5th Street
1715 5th ST NW
Traffic Circulation Layout

Response to review dated August 9, 2021

1 Site Plan
Scale: 1" = 20'-0"

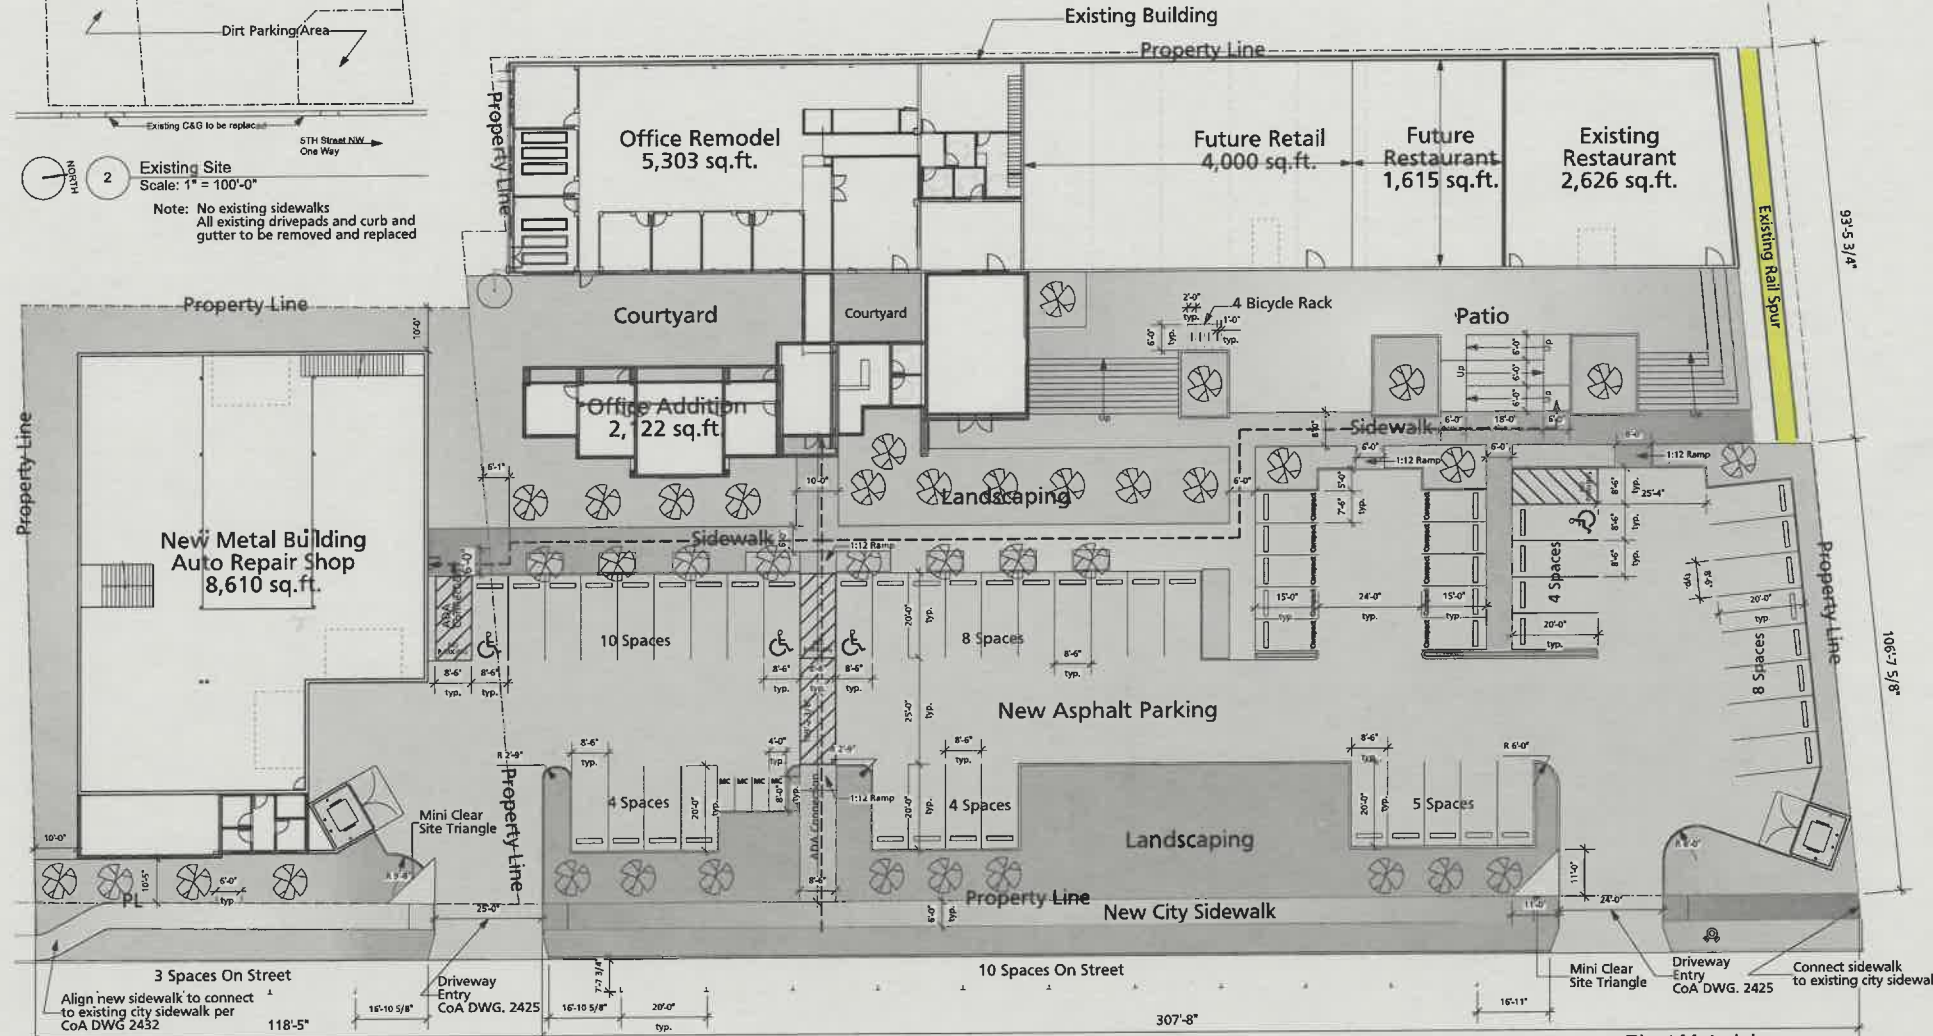
1. Added
2. Corrected
3. -Southern sidewalk will realign by shifting to the curb line
-Northern sidewalk will connect directly
Added note 2415A to #3 Detail
4. No impact anticipated we will not interfere with the railroad infrastructure
5. Added note 1:12 slope all HC ramps
6. Added
7. -
8. Attached
